Planning application reference AW/181/15/HH

With reference to the above planning application, I wish to object to the proposed development on the following grounds:

project:	11 Marquis Way - Aldwick		
drawing title:	Proposed Site Plan		
drawing status:	Planning Application		
date:	20 - 06 - 2015	scale at relevant drawing size 1 : 50 (A1) or 1 : 100 (A3)	no: JW131105 - PL10
rev:	B

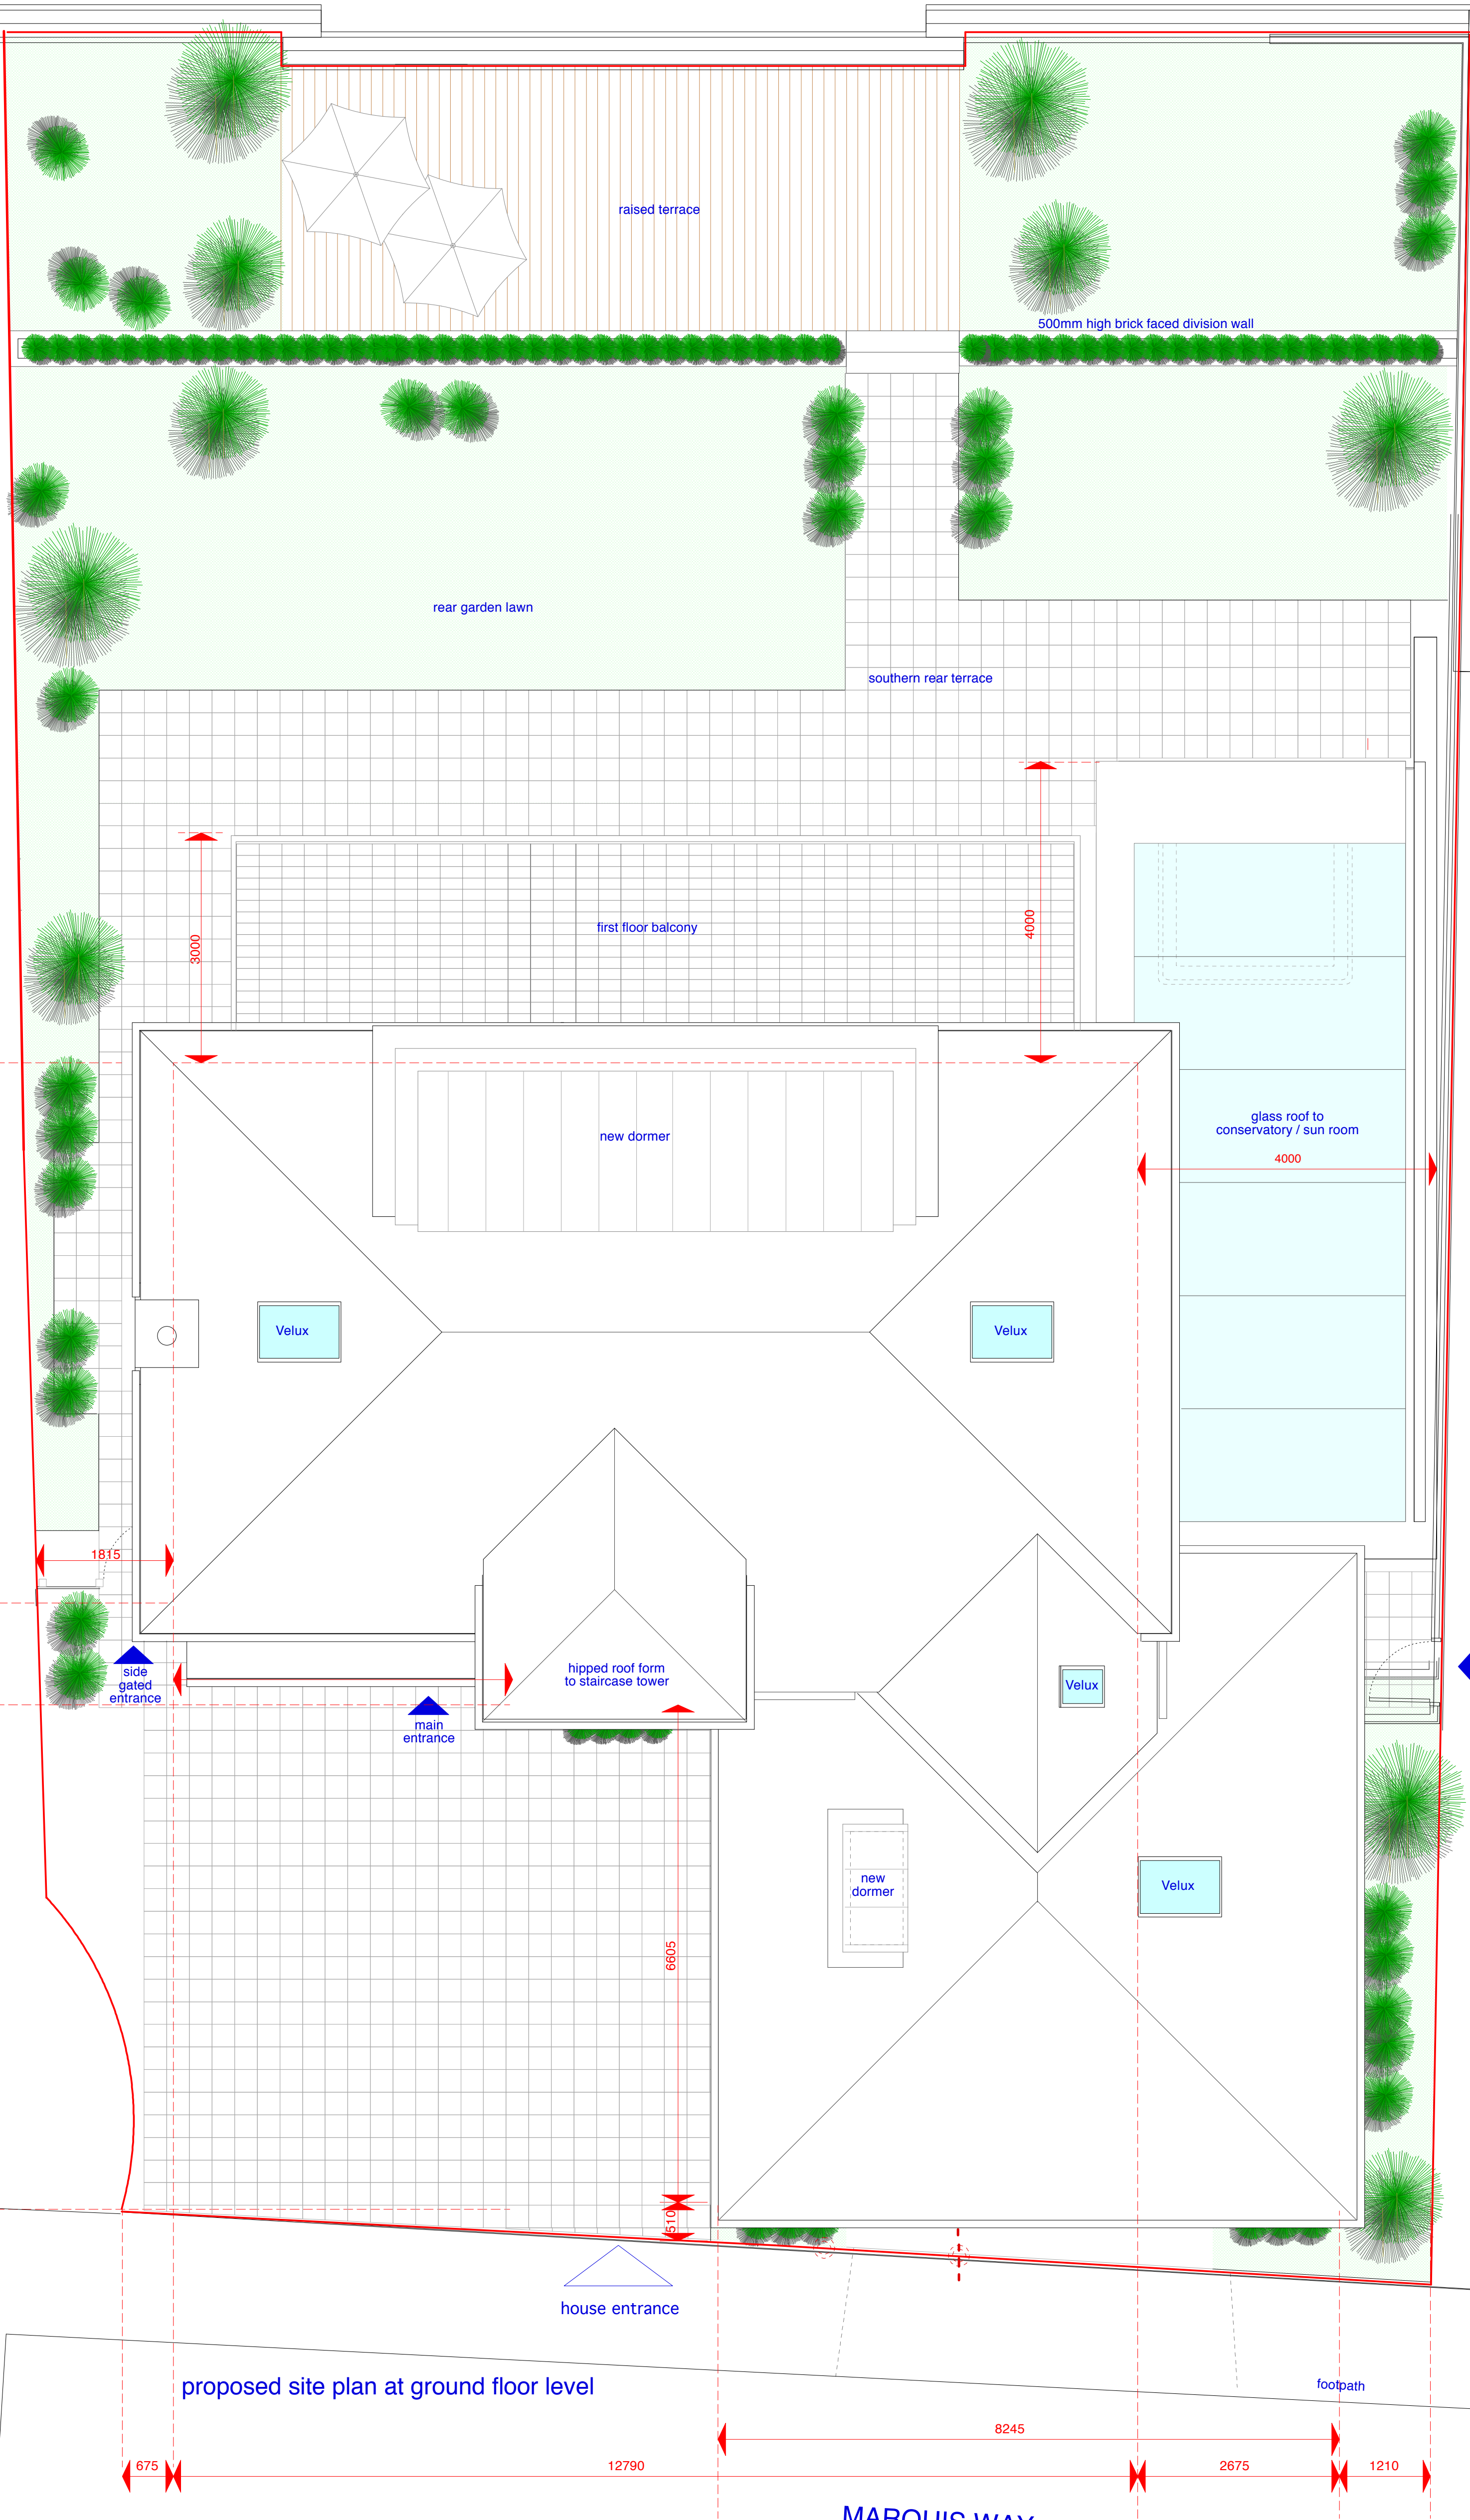
Instead of using the commonly agreed building line across the rear of all six seafront properties, the applicant has attempted to create an artificial building line drawn from the most southerly point of the 'Aldwick Hundred' property, which is not even on the Marquis Way estate and is therefore totally irrelevant in the context of this application.

Given that the six seafront properties are highly visible both from Marquis Way and from the Aldwick beach, they are regarded as 'dual fronted', and therefore the proposed the ground floor conservatory would infringe the true building line on the southern side of the property. It is understood that in an application in 2005 on a similar Marquis Way property, the applicant was required to scale back the design so as to remain within the building line.

western side elevation

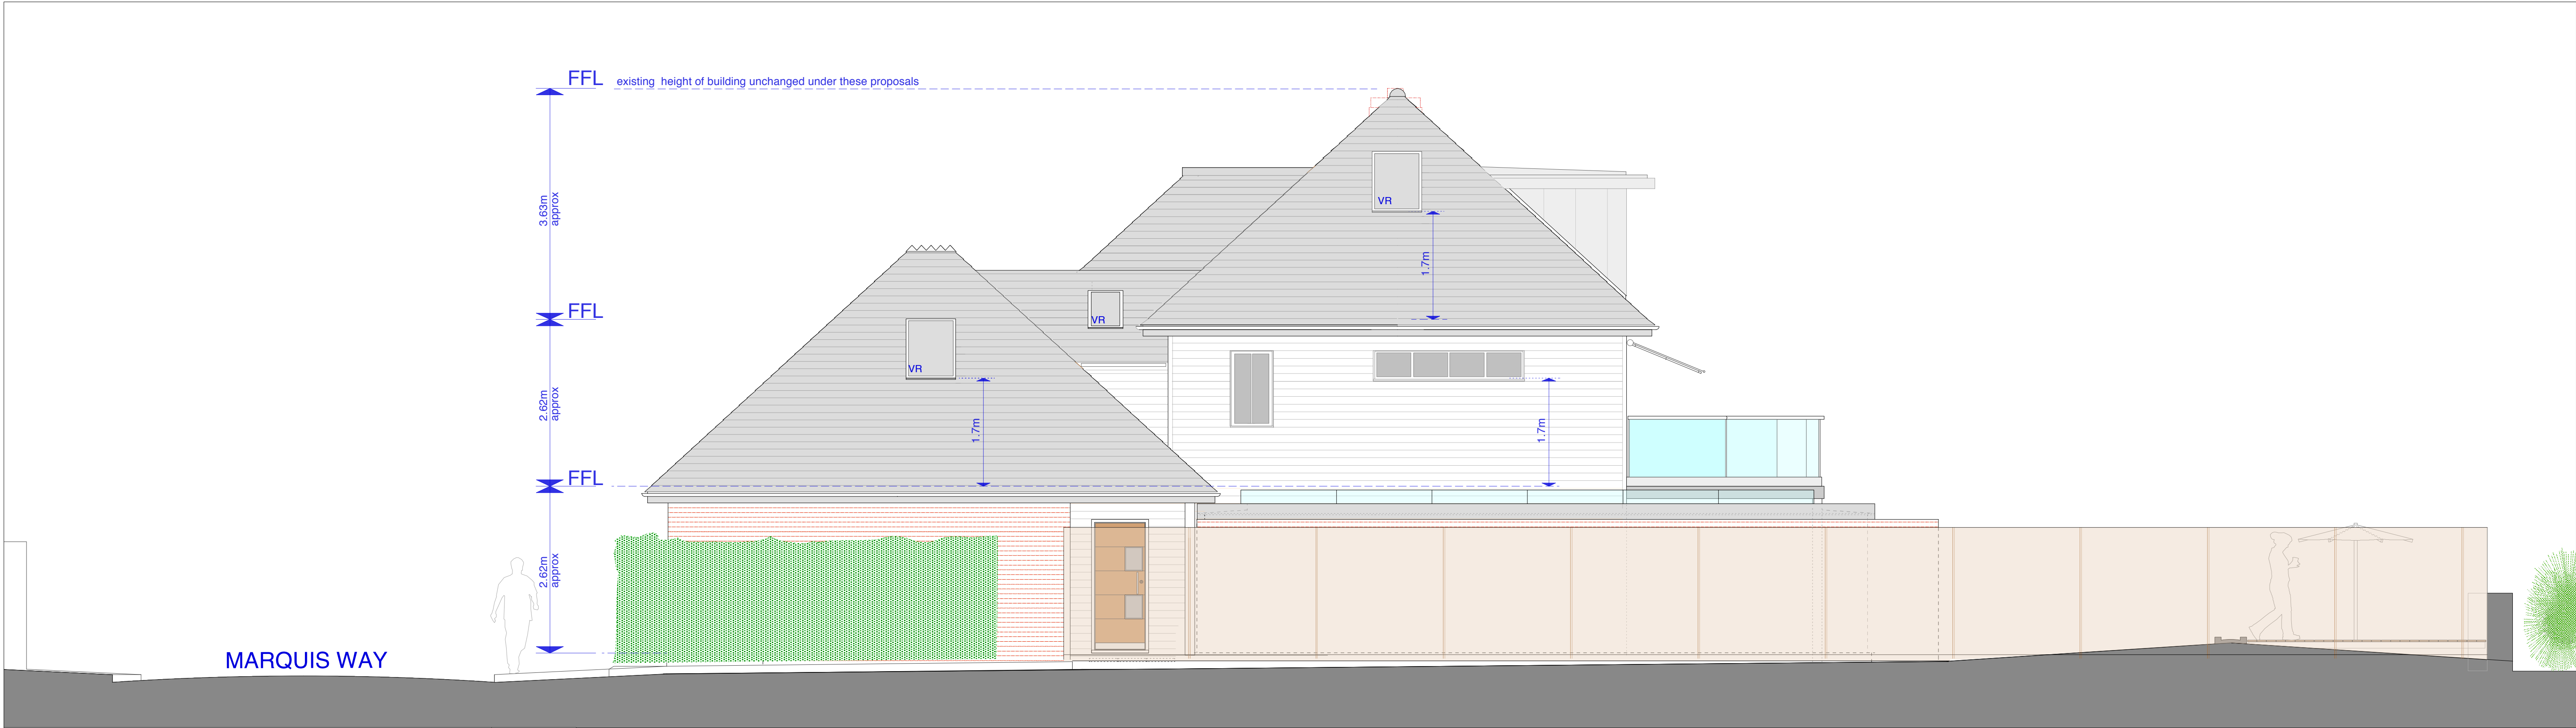
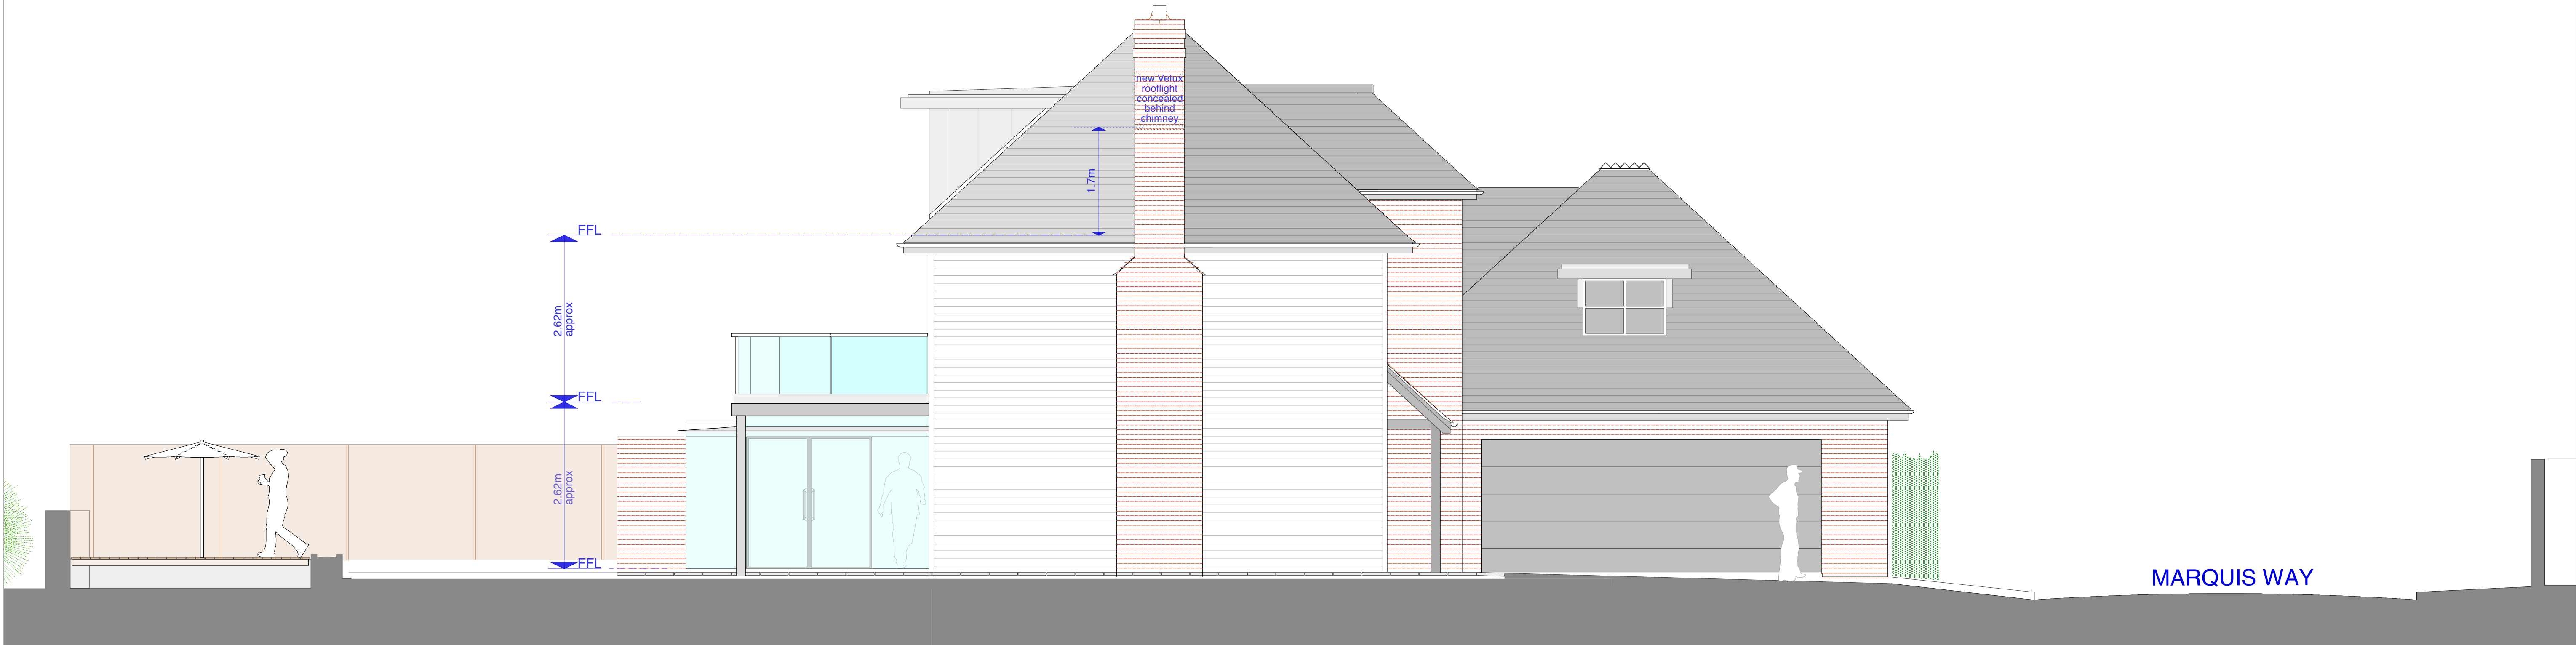
The proposal to add three 'Velux' windows and one high-level window to the western aspect of the property would also greatly increase overlooking of the garden and house at number 12.

south elevation onto the beach

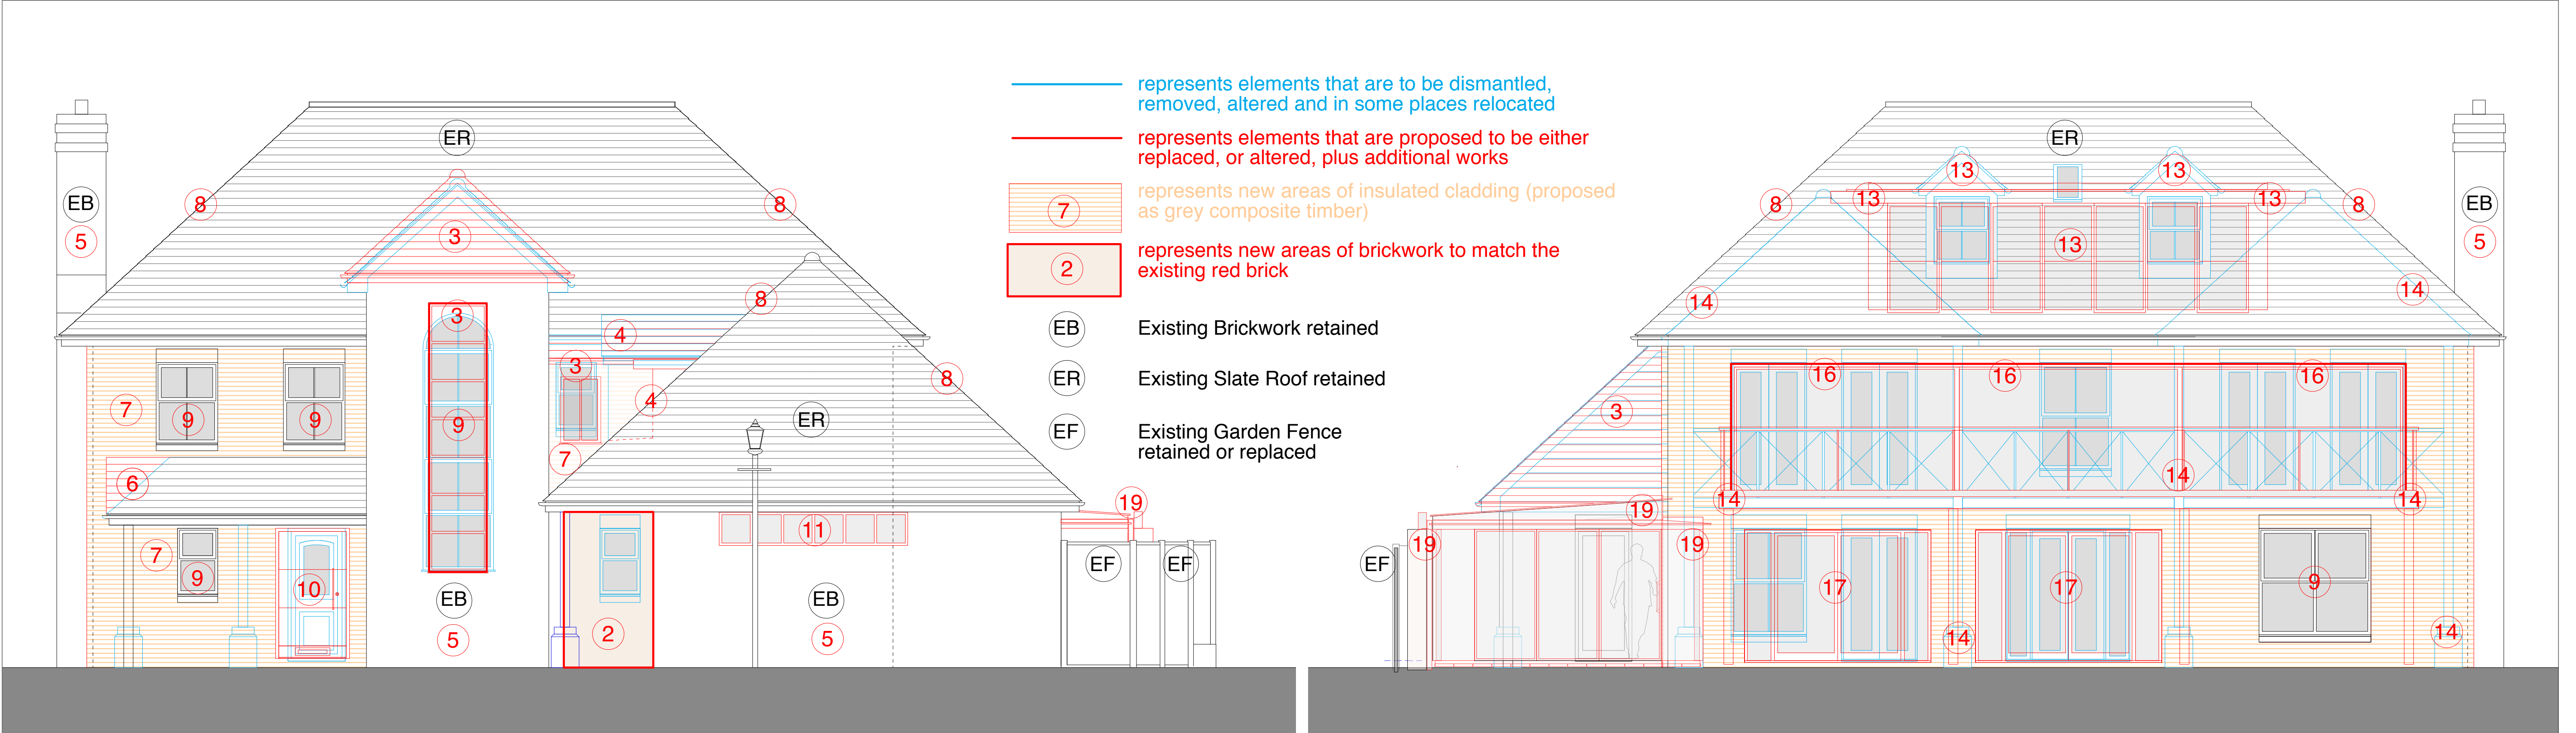
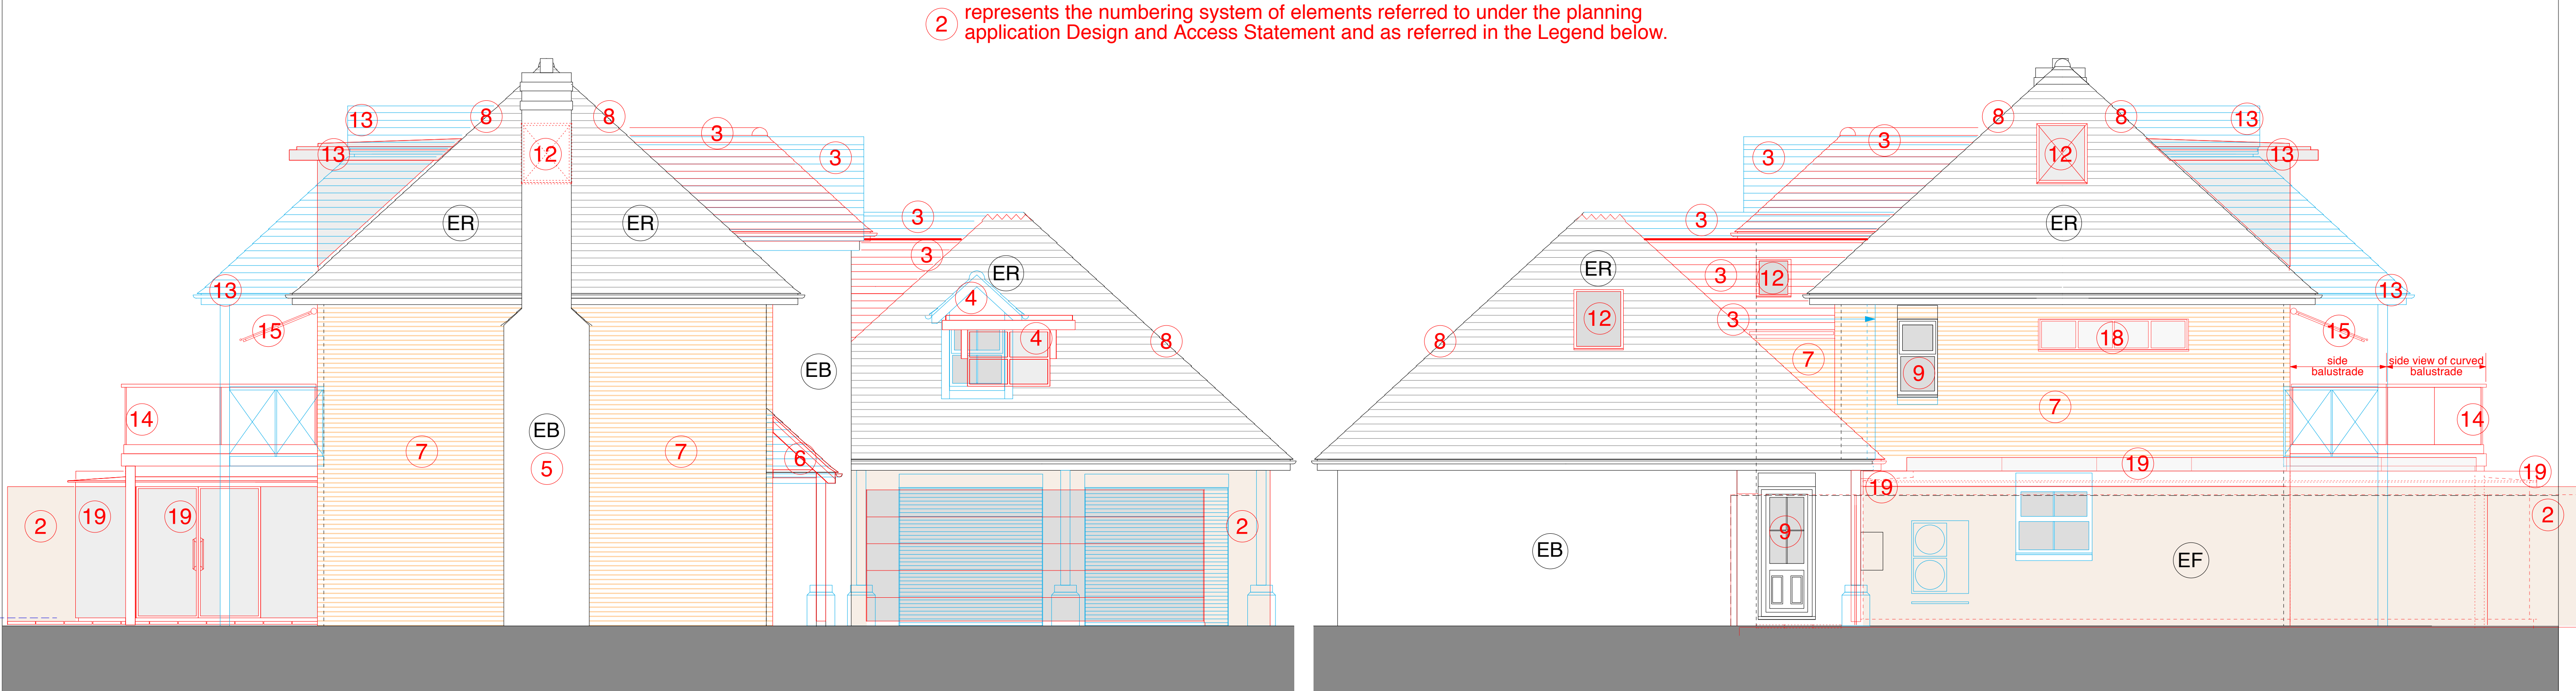
The change of roofline and second floor windows on the southern aspect of the property represent a considerable change from the present design.

The proposed first floor balcony would be considerably deeper than at present, resulting in increased intrusive overlooking to number 10 to the east and number 12 to the west.
